KITTITAS COUNTY

DEPARTMENT OF PUBLIC WORKS

MEMORANDUM

SUBJECT: Maclsaac Short Plat SP-16-00003

MacISAAC SHORT PLAT  
 PART OF SECTION 34, T. 20 N., R. 15 E., W.M.  
 KITTITAS COUNTY, WASHINGTON

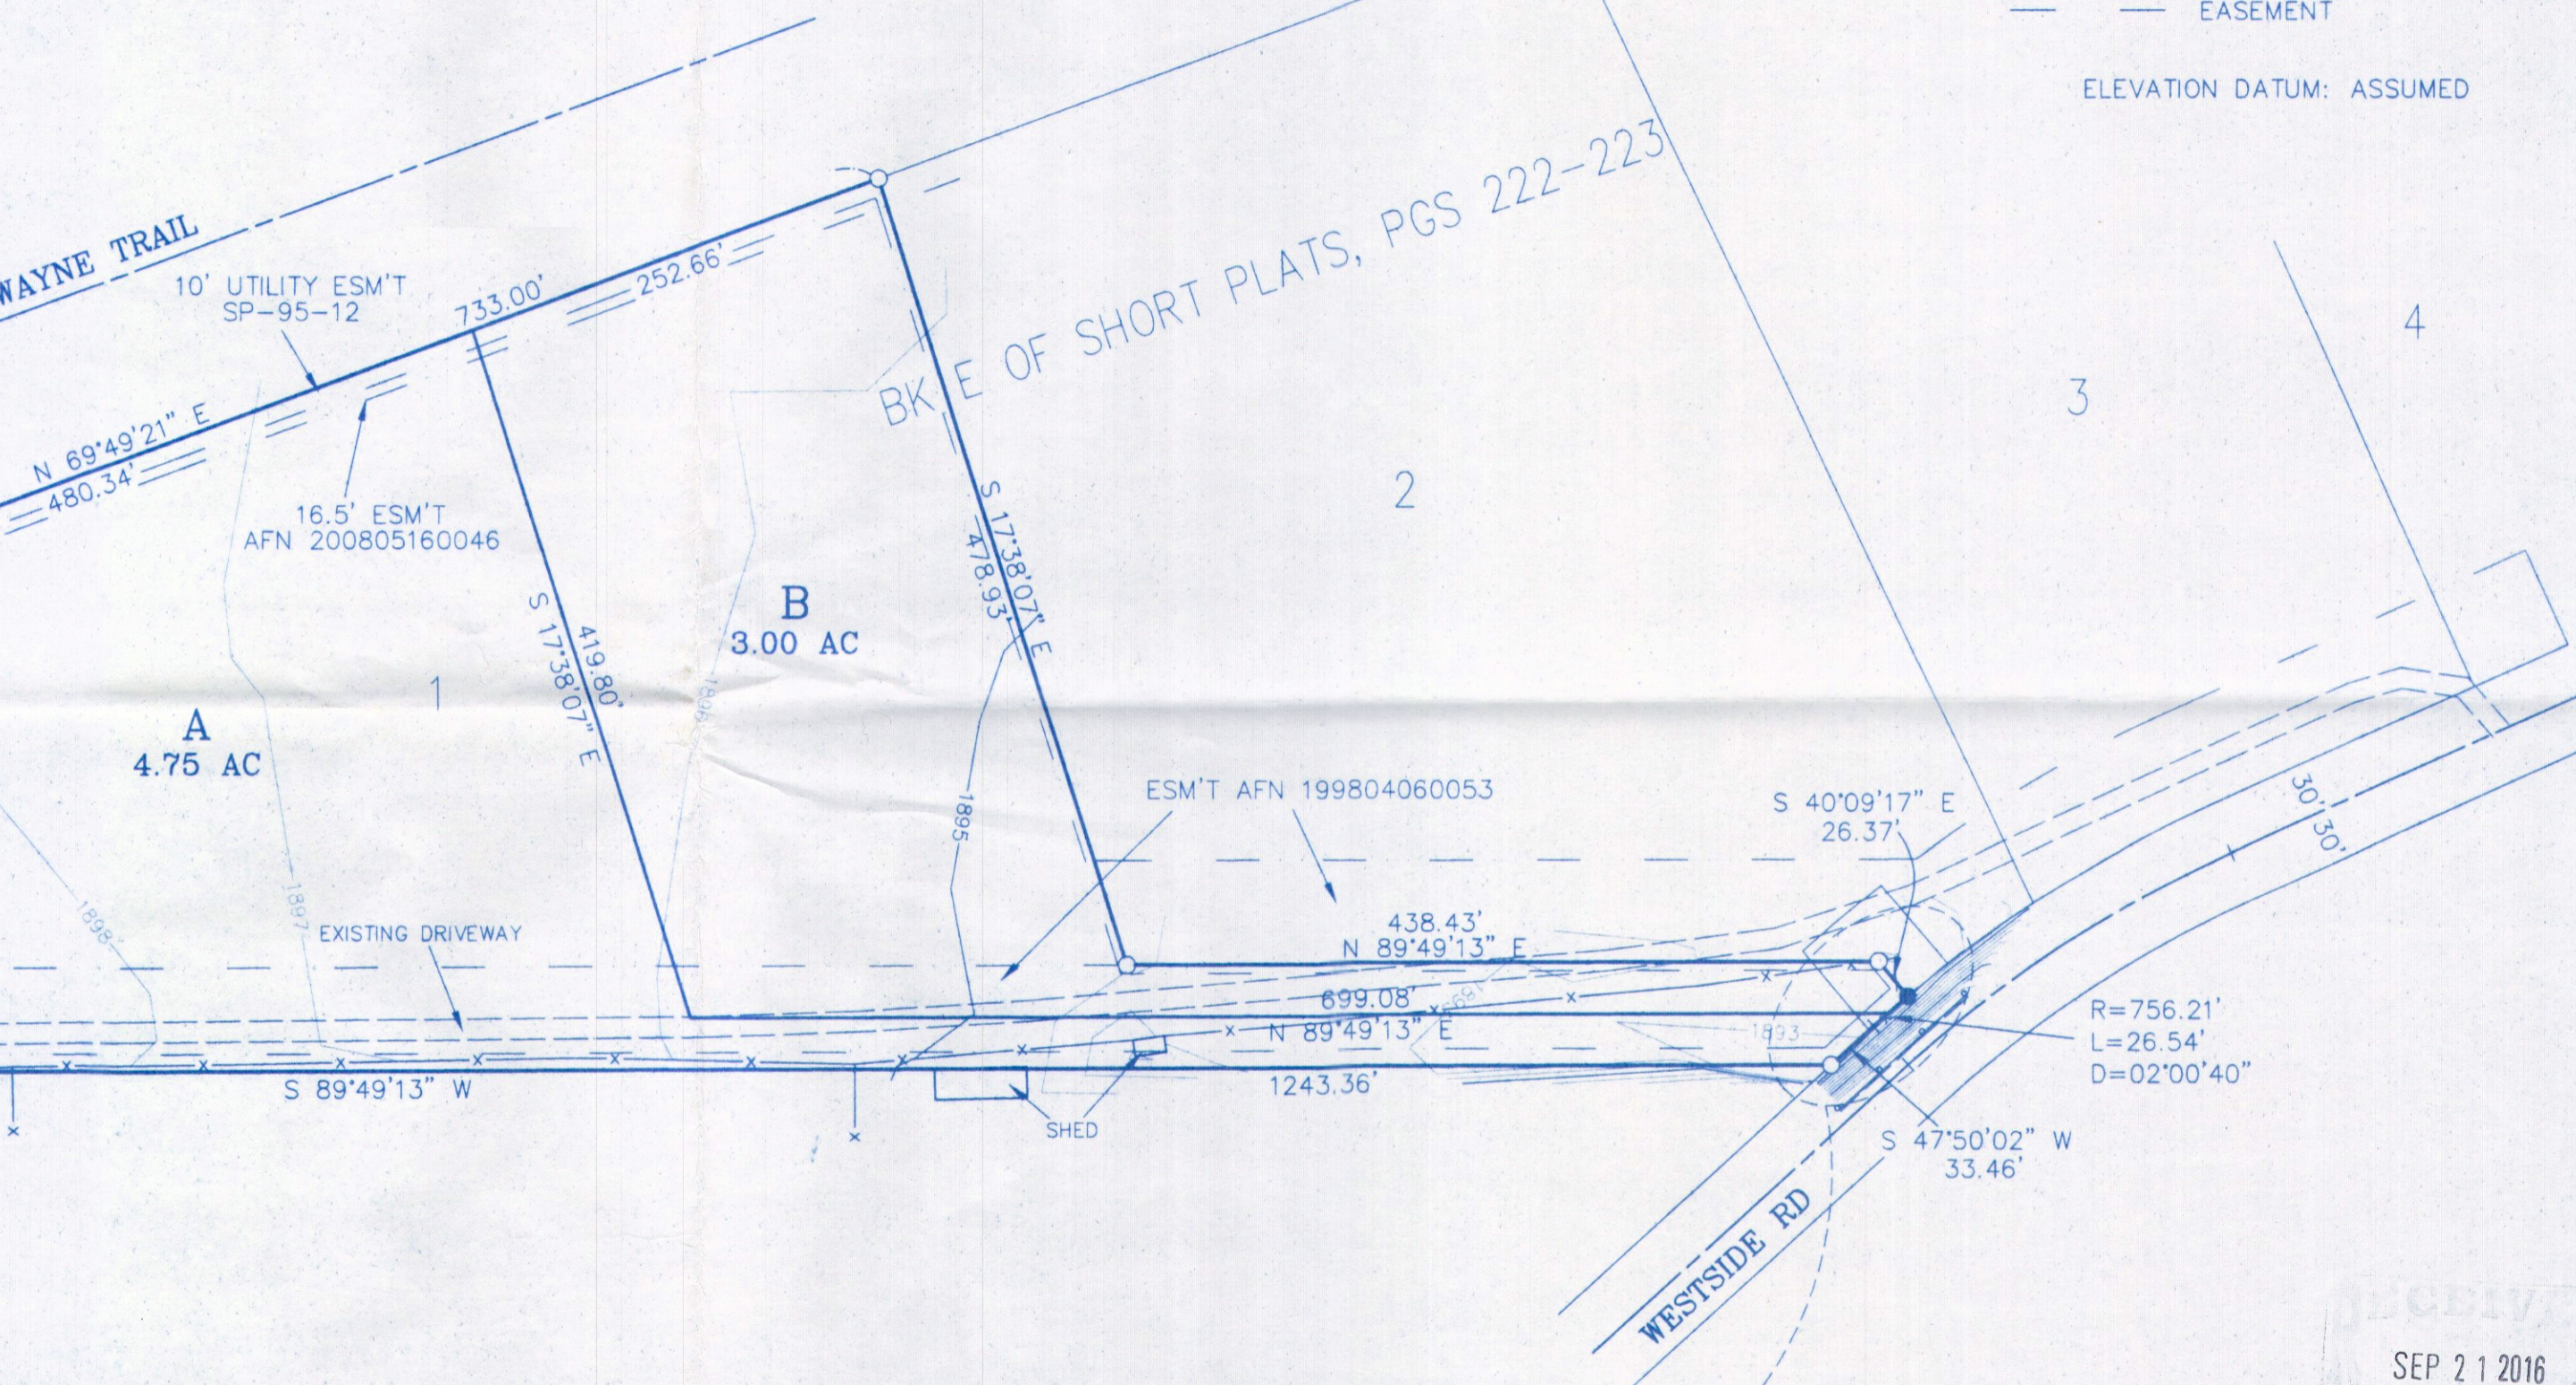
1. Transportation Concurrency: An application for Transportation Concurrency required to be completed prior to final approval.
2. Access: Access is restricted to the 60' access easement, Auditor's Recording No. 199804060053 for access to lots 1 through 4 of the Rodney T. Dunn SP. 95-12 and lot B of BK19 pg. 181-182.

5. Private Road Improvements: Access from Westside Road shall be constructed as a Low-Density Private Road. See Table 4-4, current Kittitas County Road Standards, 12/15/15 edition.

- a. Access easements shall be a minimum of 60' wide. The roadway shall have a minimum width of 20', with 1' shoulders, for a total width of 22'.
 - b. Minimum centerline radius will be 60'.

- c. The surface requirement is for a minimum gravel surface depth of 6".
 - d. Maximum grade is 10%.

- i. All easements shall provide for AASHTO radius at the intersection of county road.
 - j. A paved apron shall be constructed at the intersection of the proposed private intersection and the county road right of way.
